# CITY OF ALBUQUERQUE

**Re: FedEx Ground ABQ Drainage Report and Grading Plan and Drainage Plan  
Engineer's Stamp Date 8-12-14 (K09D026A)**

Based upon the information provided in your submittal received 8-12-14, the above referenced report and plan cannot be approved for Grading Permit approval nor Building Permit approval until the following comments are addressed:

ENGINEER'S SEAL		FEDEX GROUND ALBUQUERQUE, NM		DRAWN BY DY	
		PRE DEVELOPED DRAINAGE BASIN MAP		DATE 7-3-14	
		TERRA WEST, LLC 5571 MIDWAY PARK PLACE NE ALBUQUERQUE, NM 87109 (505) 856-3100 www.terrawestllc.com		2013075-BASINS	
				SHEET # C2	
RONALD R. BOUWMAN P.E. #7868				JOB # 2013075

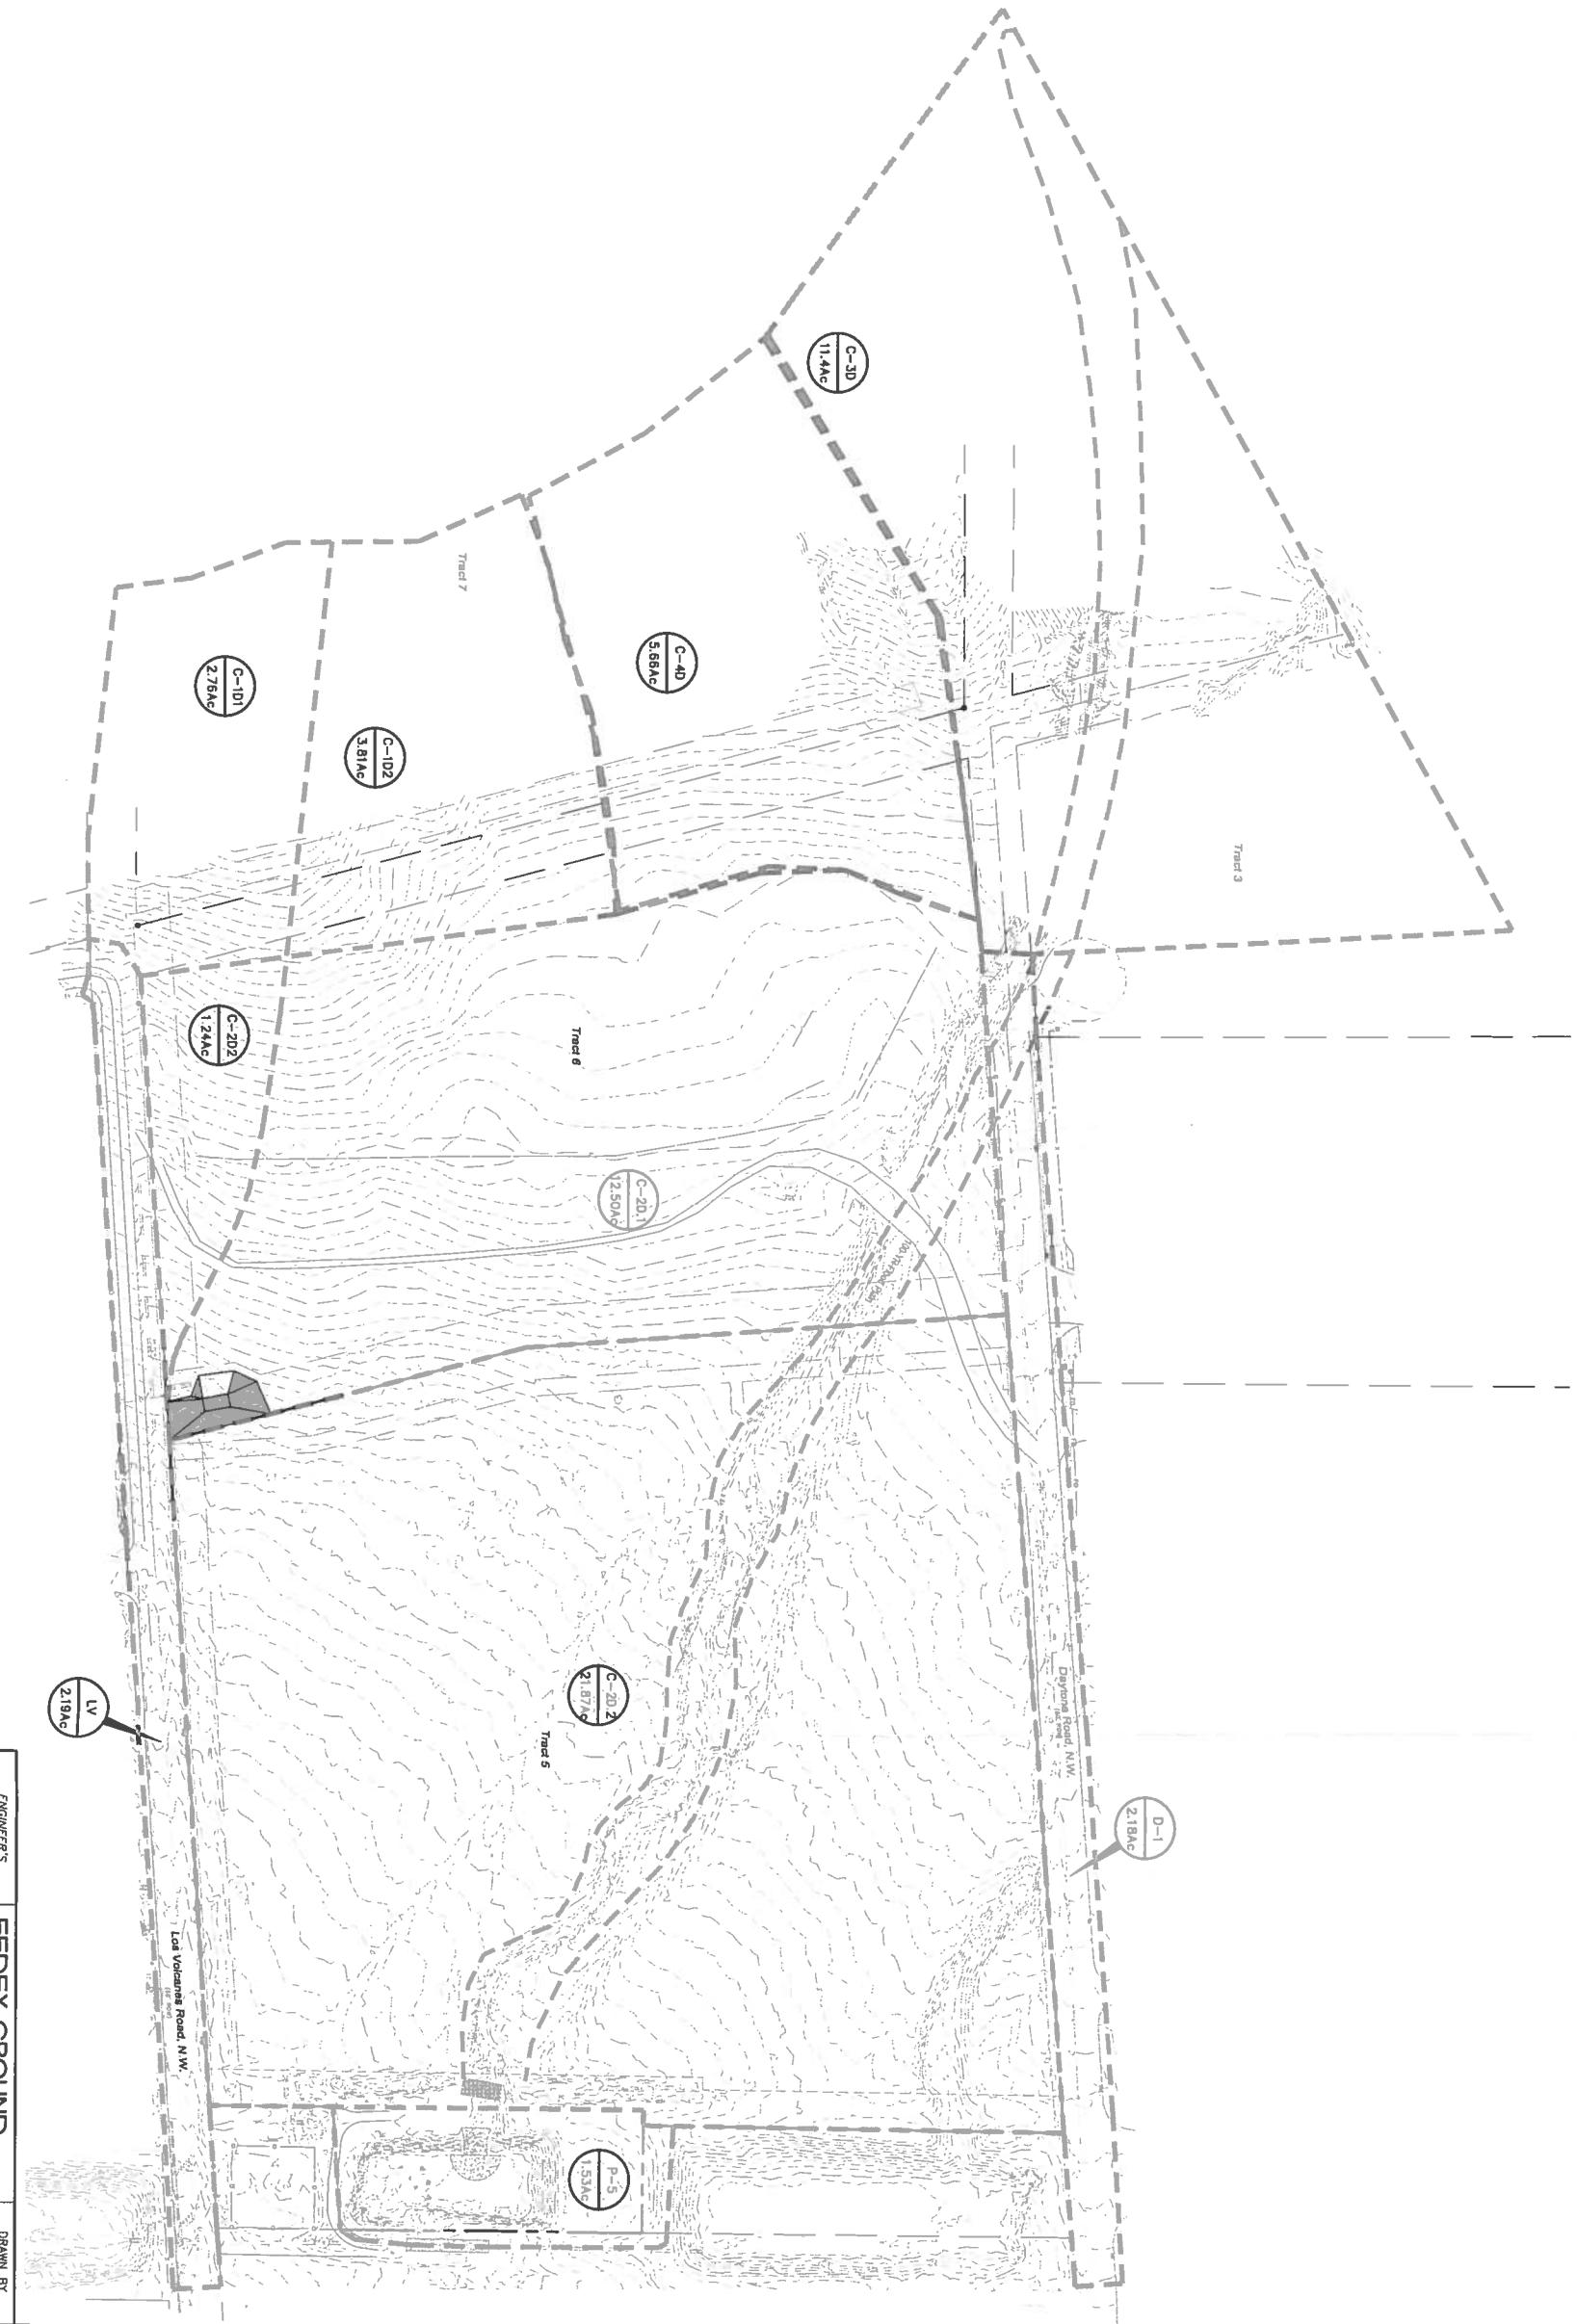
1. Provide contours for the western portion of the Pre and Post Developed Drainage Basin Maps. Show the current layout of the Daytona ROW going through the western basins on the Basin Map. Show the desilting pond and storm drain west of Daytona Road on the Post Developed Drainage Basin Map. West of Daytona, construct desilting pond slopes outside of the ROW and extend the proposed storm drain as necessary. Provide the updated Daytona Road Grading and Drainage Improvements sheet, GR-6, which was submitted with the previous submittal but not this one.

ENGINEER'S SEAL	FEDEX GROUND ALBUQUERQUE, NM		DRAWN BY DY
POST DEVELOPED DRAINAGE BASIN MAP		DATE 7-3-14	
		2013/75-BASINS	
SHEET # C2		JOB # 2013075	
RONALD R. BOHANNAN P.E. 17668

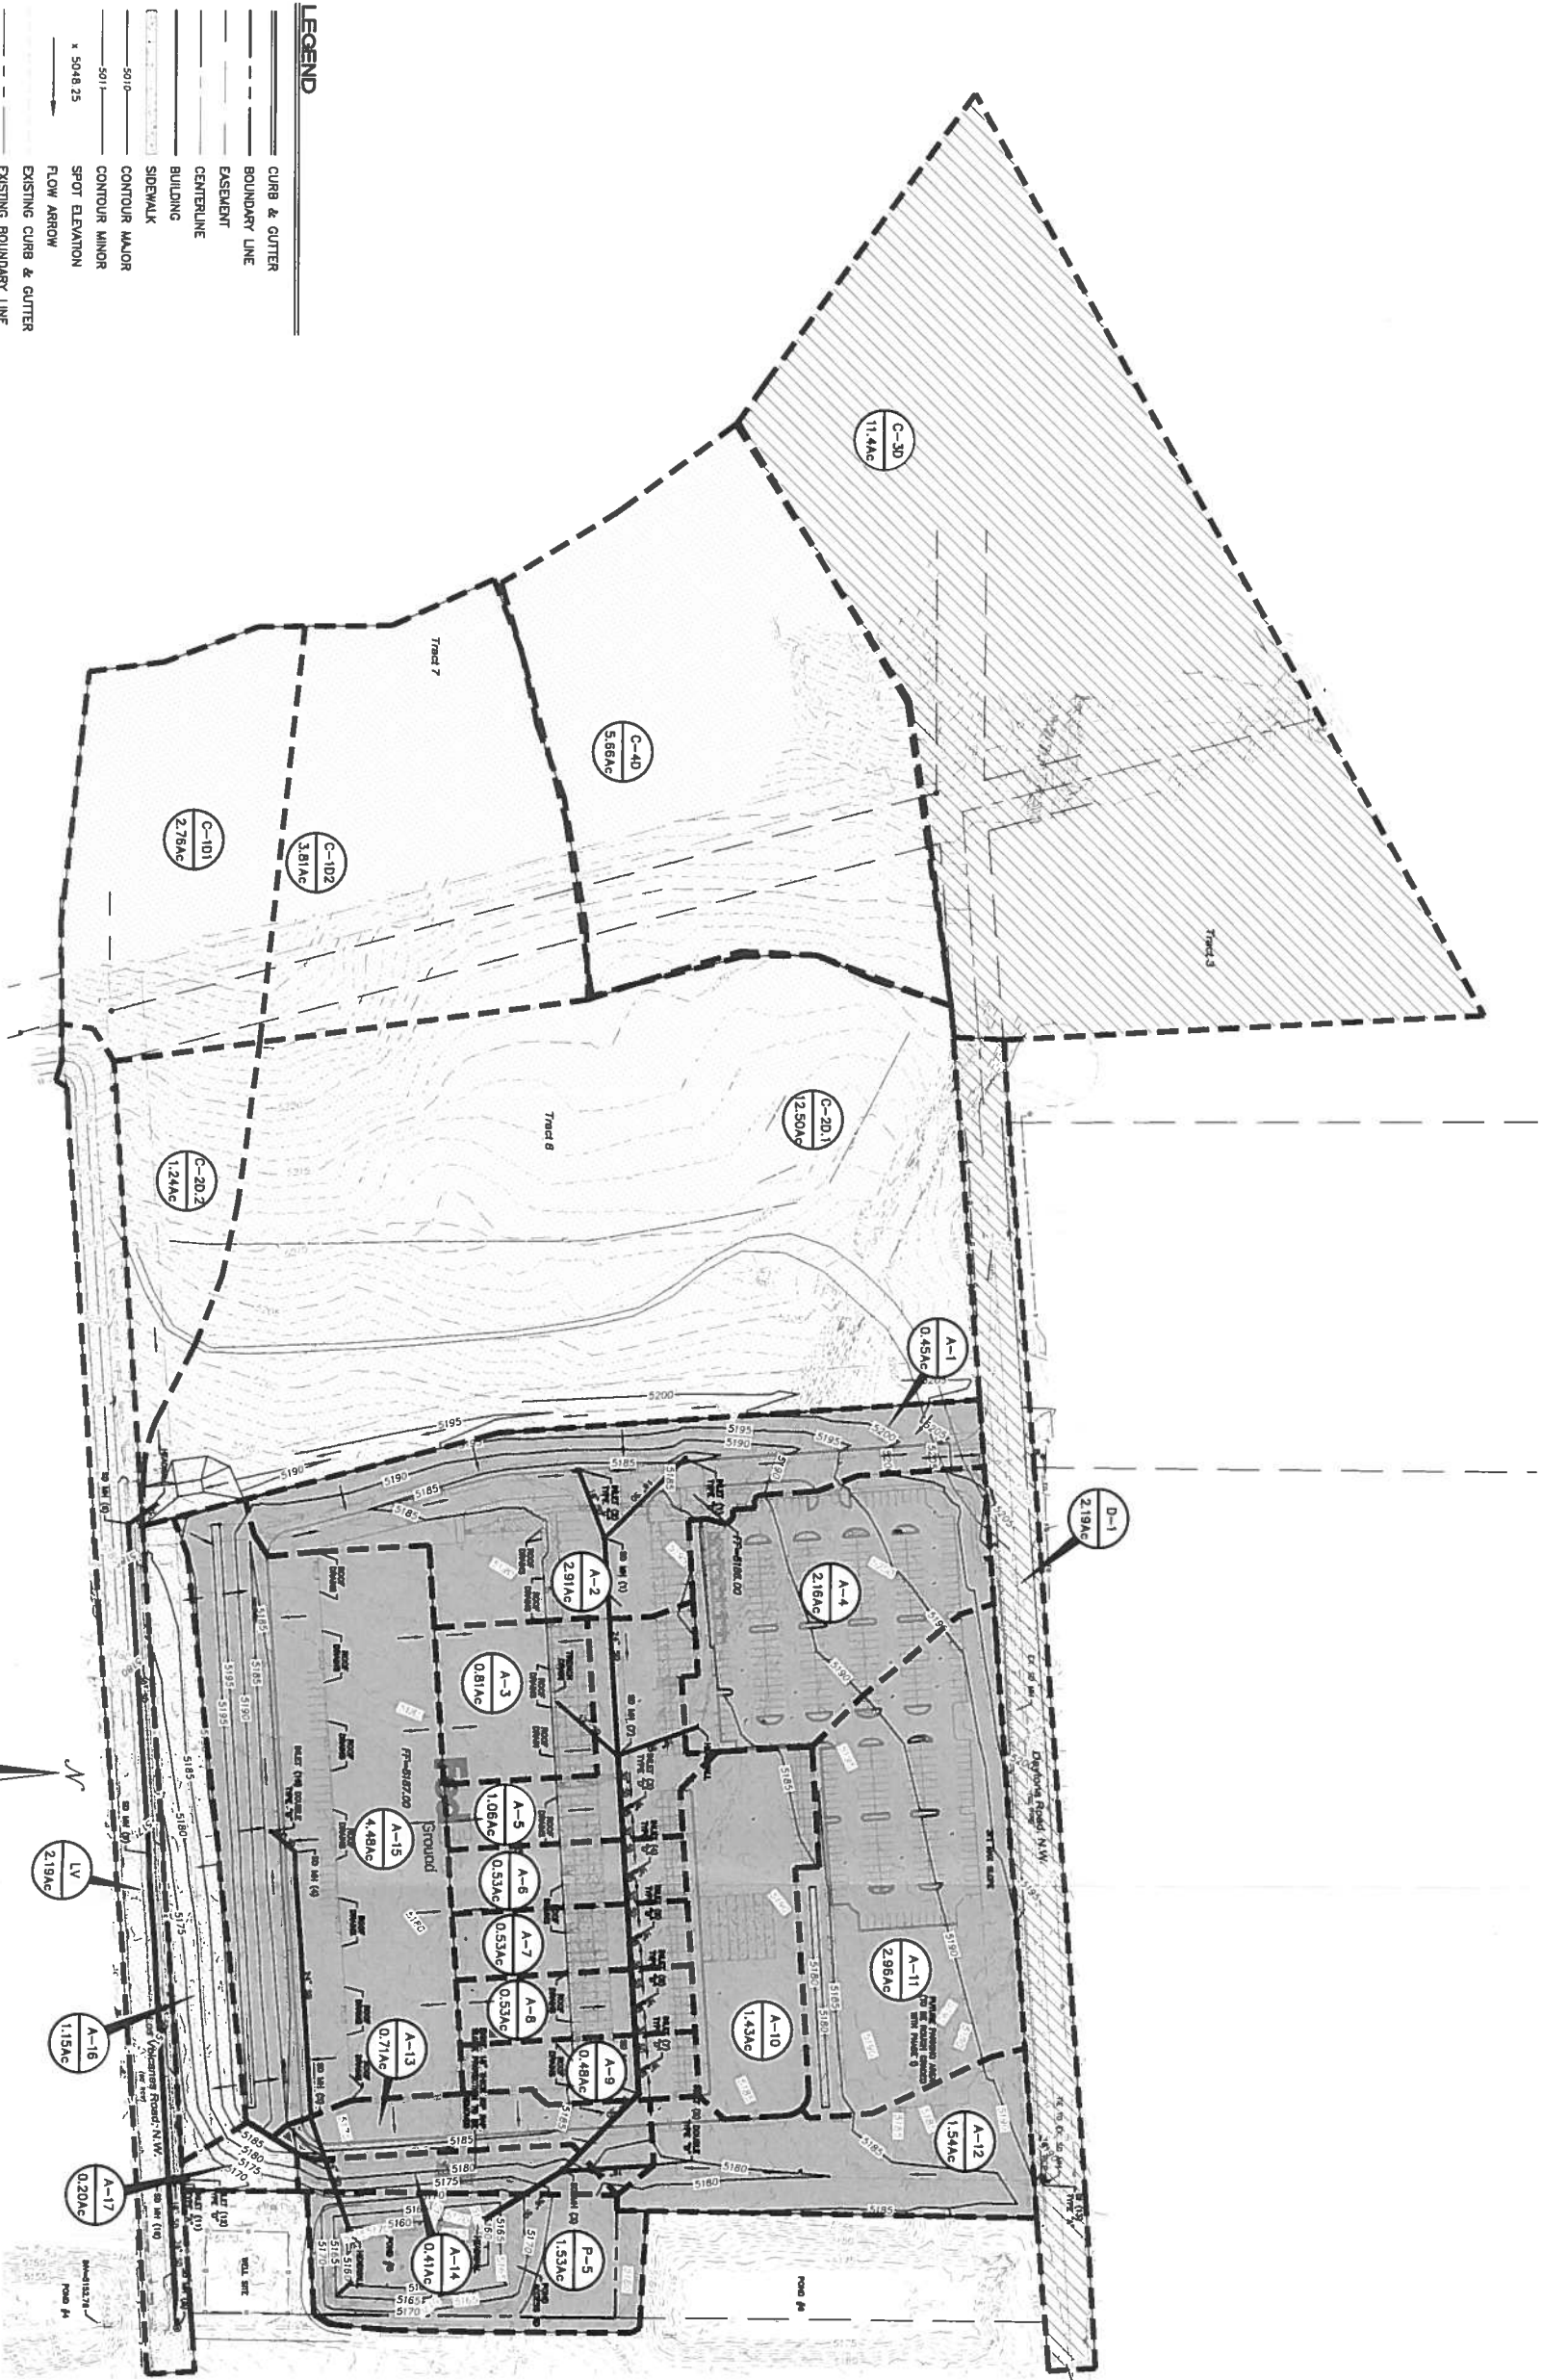
3. On the Post Developed Drainage Basin Map, Basin C-4D is shown with a shading indicating the flows will go to Daytona Road and eventually Pond 6. However, the report says the flow from Basin C-4D will go east eventually to Los Volcanos Road. The Daytona Road Storm Drain Master Plan for the West Side Transit Facility by Smith Engineering shows that area should go to Daytona Road. Please revise the report.

for inlets 11 and 14. Show inlet 14 on the Post Developed Drainage Basin Map. On GR-3, show what storm drains will be abandoned with CPN 655784.
